MECKLENBURG COUNTY
Park and Recreation Department

MEMORANDUM

DATE: July 12, 2021

RE: Rezoning Petition #2021-063 – Shopton/Beam Rezoning

## SITE PLAN

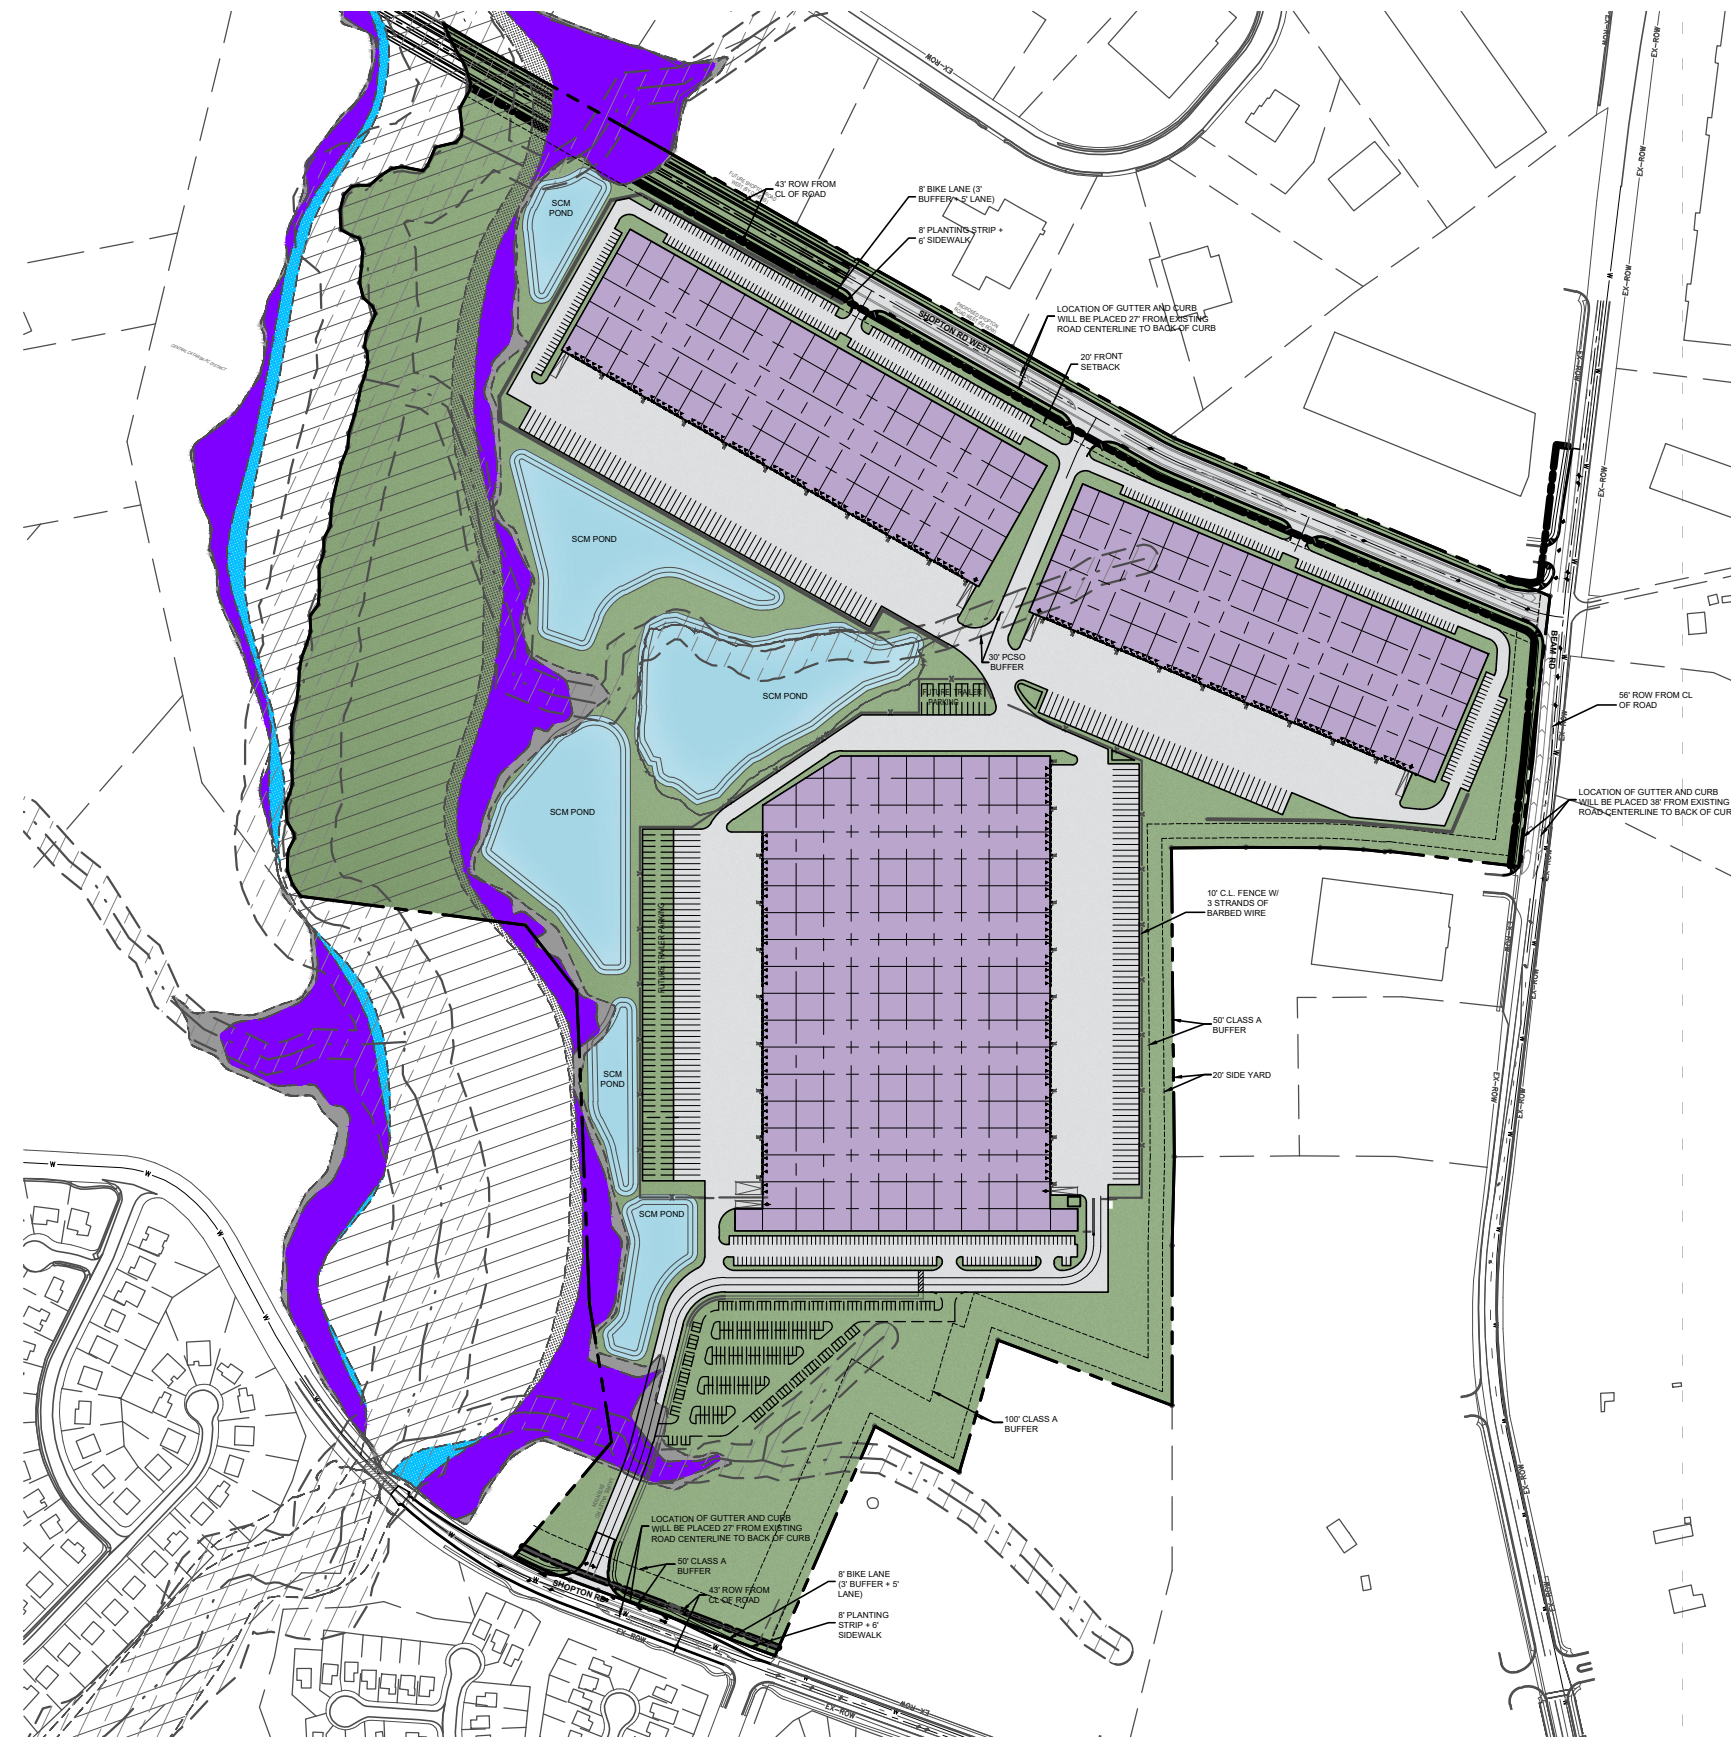
MCPR requests the petitioner dedicating and conveying or providing a greenway easement of the same area to Mecklenburg County - the 100' SWIM Buffer of Coffey Creek. This parcel is on the MCPR Greenway Master Plan.
